Final Acceptance (FA) Punchlist
EPC - DPW - Stormwater Section

Project Name:	Lorson Ranch East F1
EDARP Filing Number(s):	SF188, CON1958
ESQCP Number:	ESQ182
Attendees:	DPW SW: Natasha Grimaldo Developer: N/A
Date of Walk-Thru:	11-13-2023
Walk-Thru Number:	4 th

DATE:  
JUNE 12, 2018

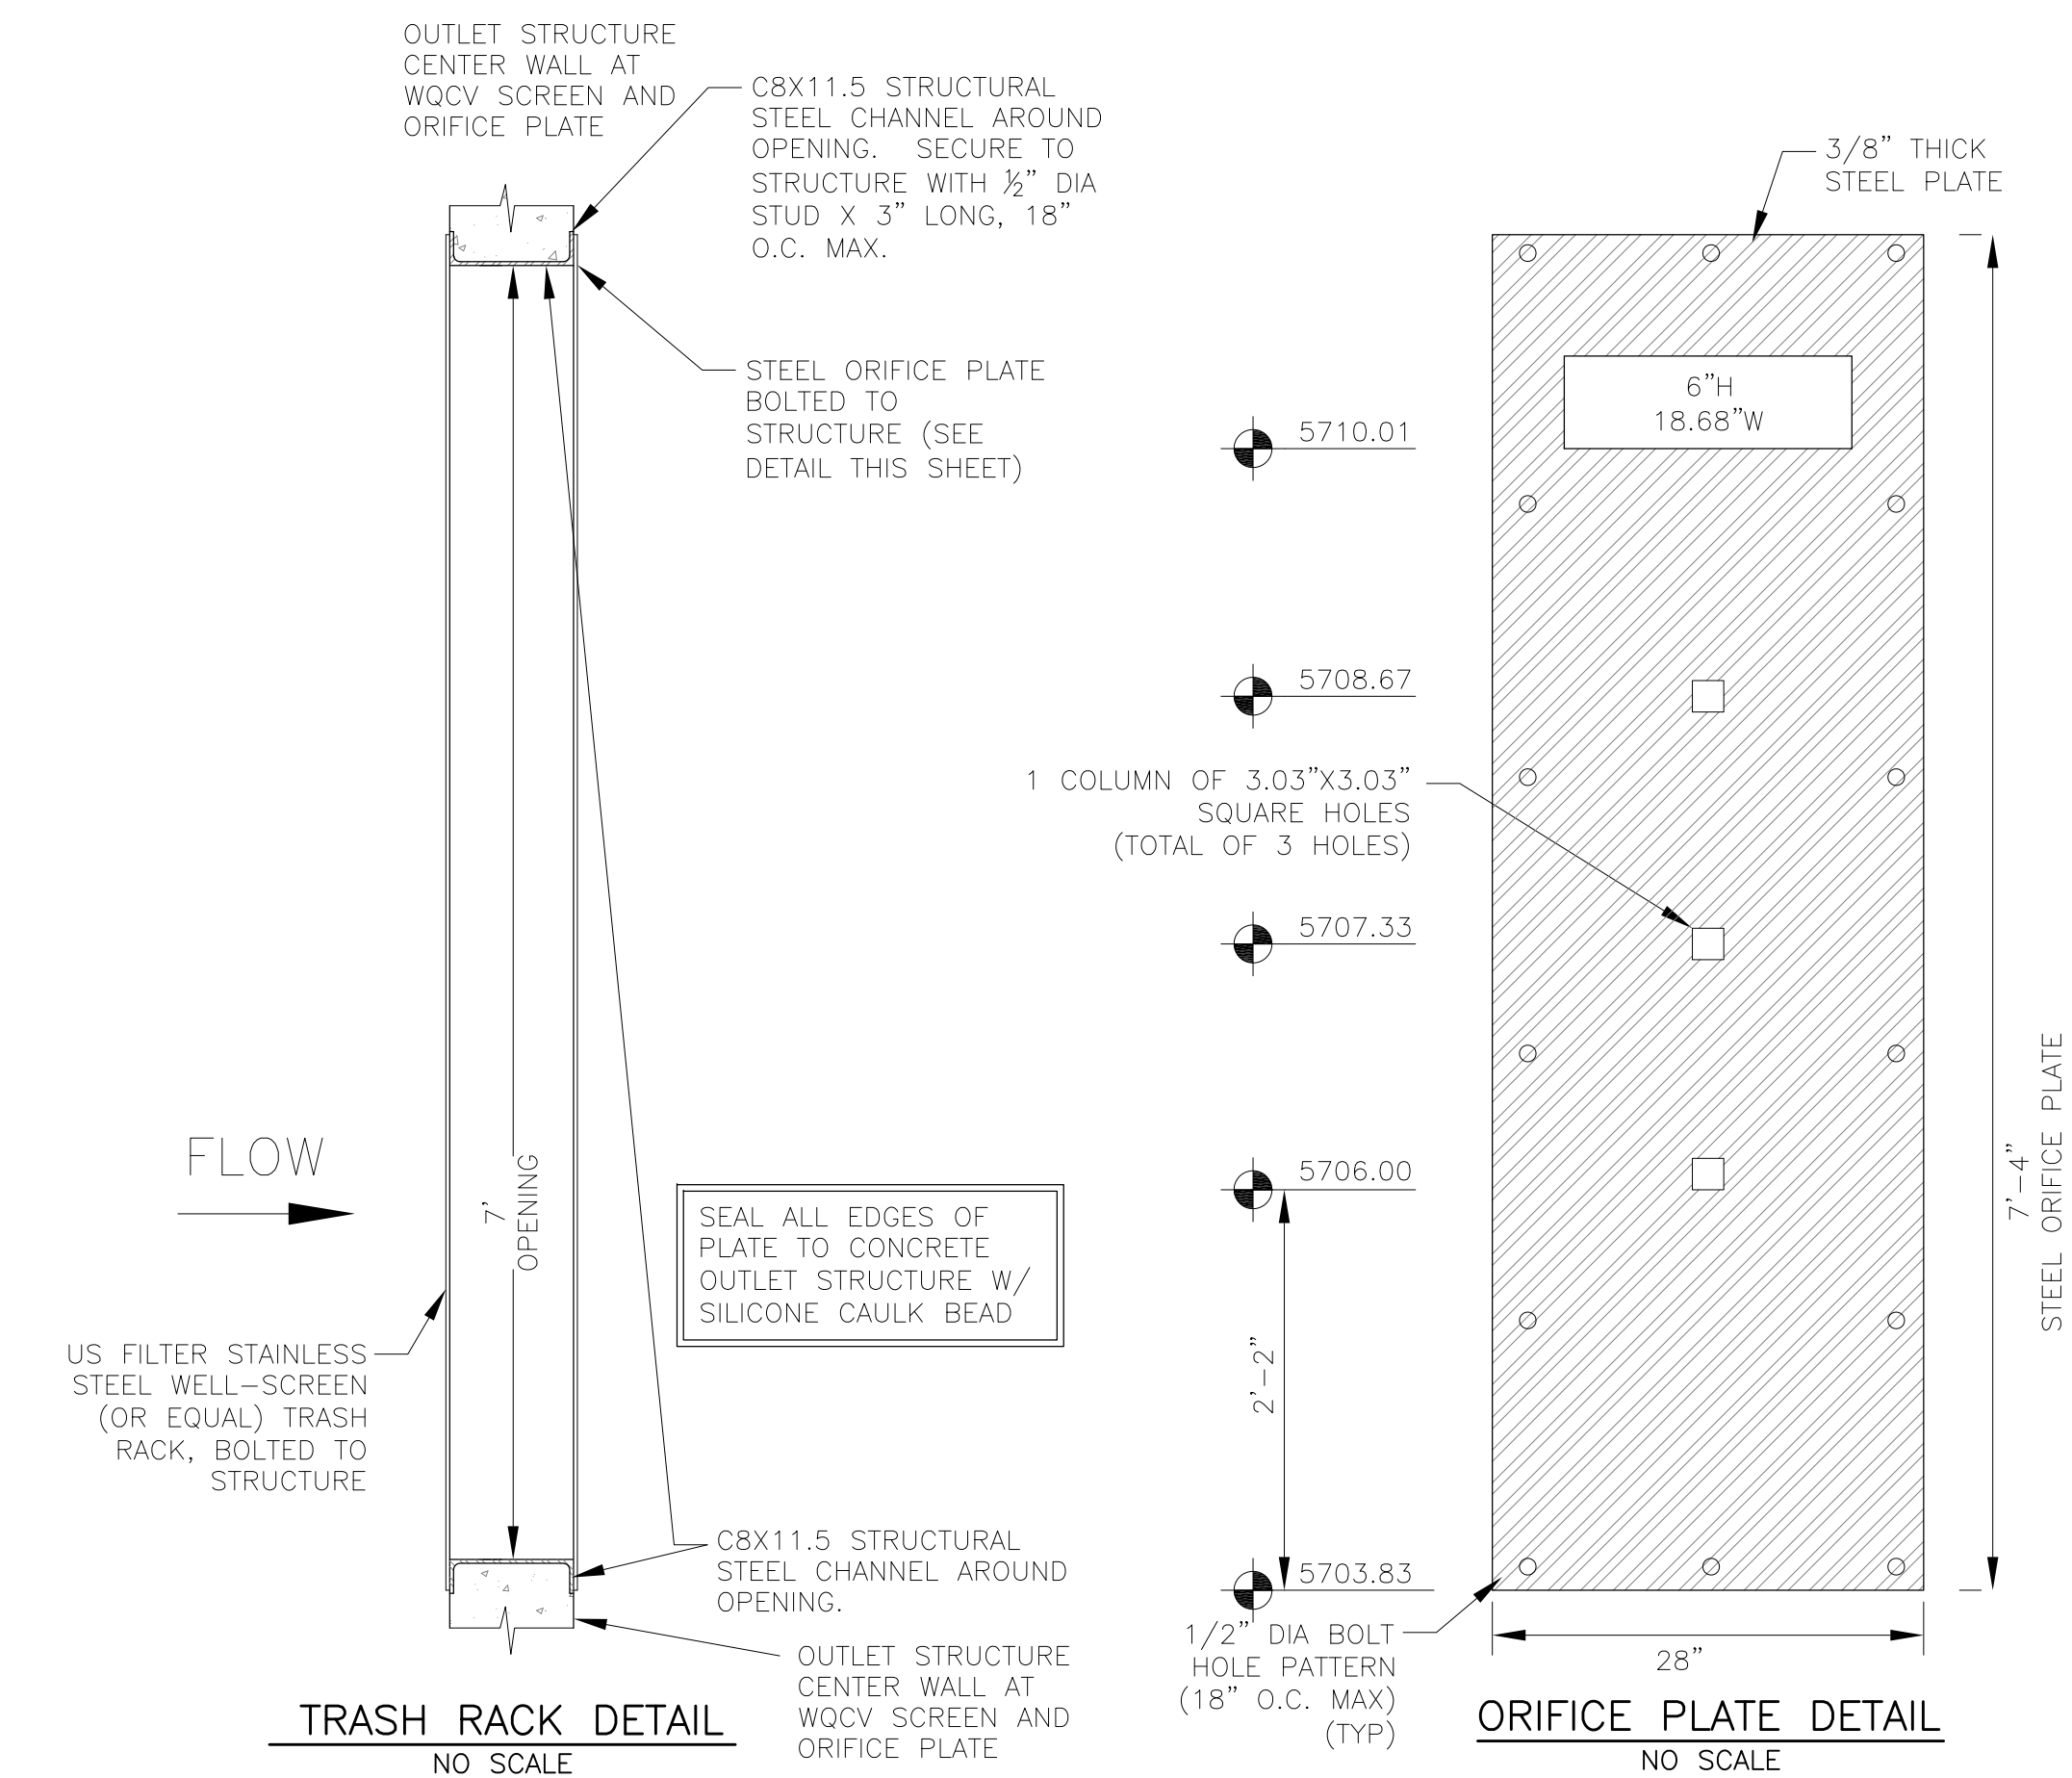
- Repair cracks in forebays and trickle channels.
- Remove sediment and debris from outlet pipe.
- Remove rock sock from forebay notch in forebay B.
- Implement 9" D50 soil rip rap per specification on forebay A and B. Reference sheet C9.2 of CDs (or show engineered approved deviation on As-builts).
